WEST SUSSEX COUNTY COUNCIL CONSULTATION

TO:	Arun District Council FAO: Maria Tomalova
FROM:	WSCC - Highways Authority
DATE:	4 May 2021
LOCATION:	7 Ambleside Close Felpham PO22 8NG
SUBJECT:	FP/86/21/PL Erection of 1 No. 3 bed dwelling (resubmission following FP/179/20/PL).
DATE OF SITE VISIT:	n/a
RECOMMENDATION:	More Information
S106 CONTRIBUTION TOTAL:	n/a

PROPOSED SITE LAYOUT & MASSING

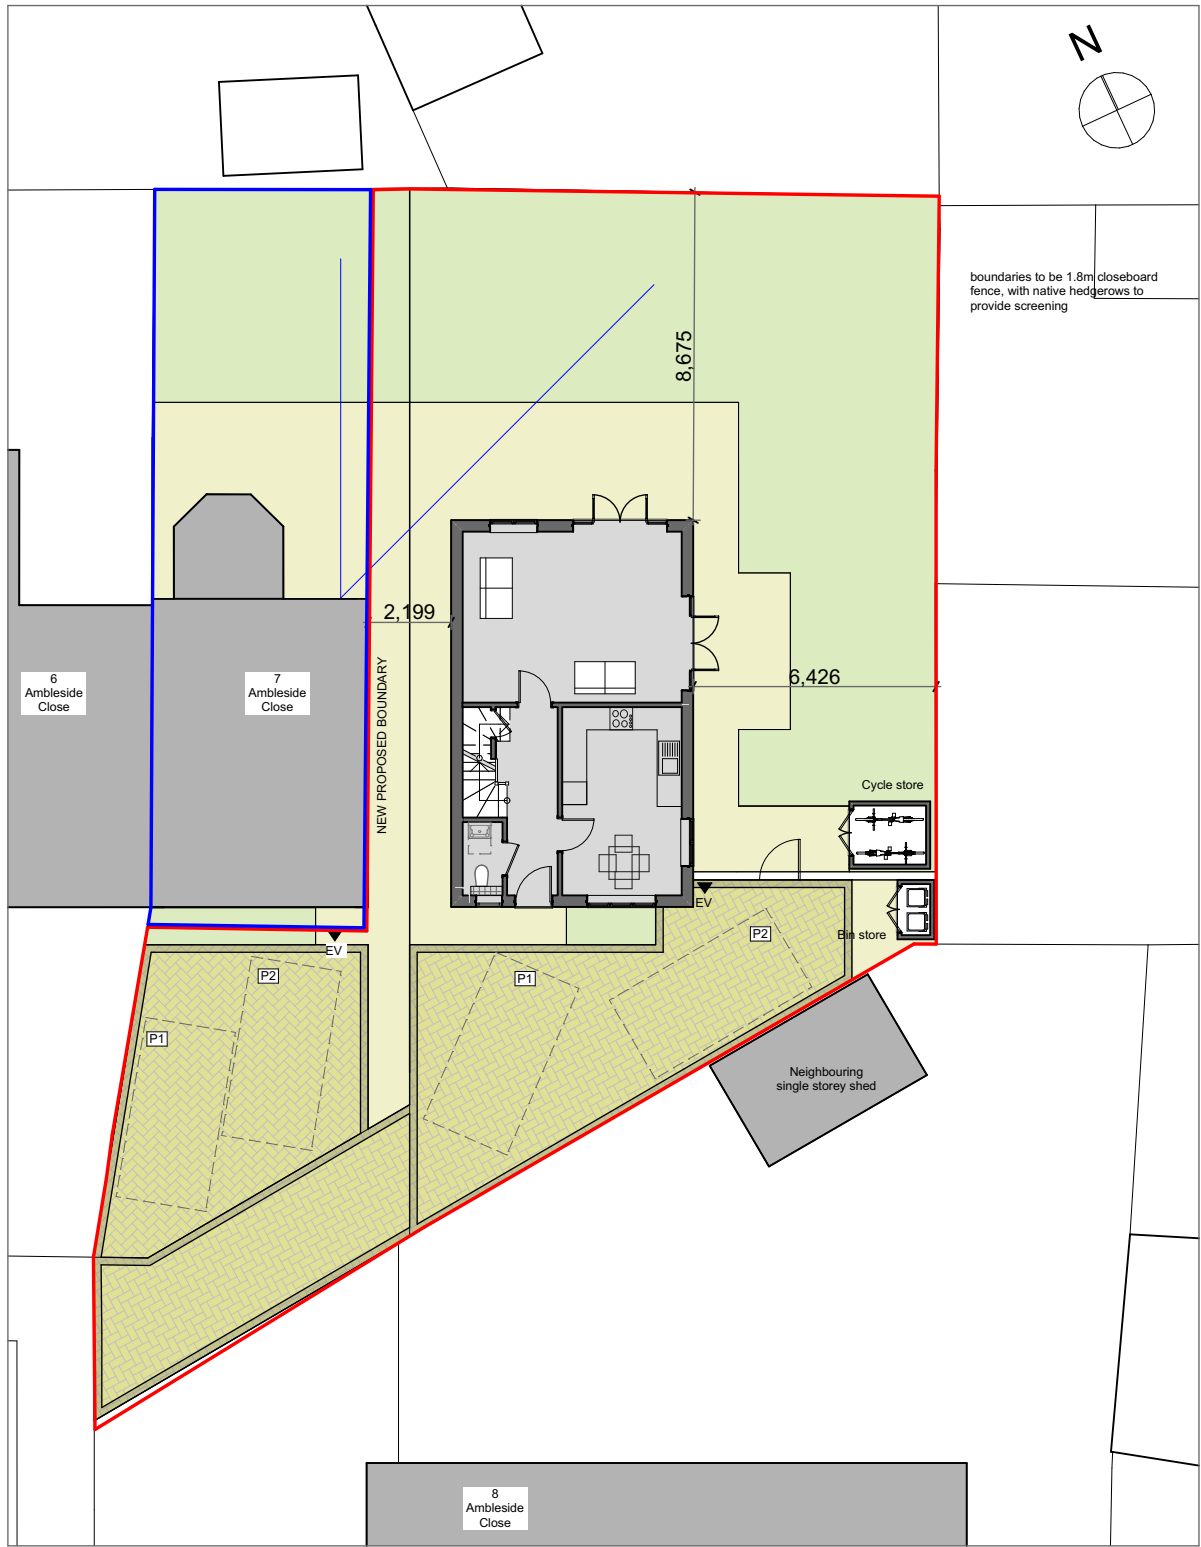
The proposal will utilise the existing access onto Ambleside Close, providing a shared driveway and two parking areas for both the existing and proposed dwellings. Whilst no visibility issues with the access arrangement are anticipated, the proposed driveway will be only 2.8m in width. It is unclear from the plans whether there will be an entrance gate to the proposed dwelling, the access width at this point appears to narrow to just 2.4m. The applicant should clarify whether an entrance gate is proposed.

The proposed parking area will provide two parking spaces for each dwelling, with no provision for vehicles to turn on site. The LHA note representations from neighbouring residents regarding the ability for vehicles to manoeuvre to and from the proposed spaces. The LHA request that the applicant demonstrate via swept path tracking that vehicles can sufficiently enter and exit each proposed parking space and can enter and exit the site from the public highway.
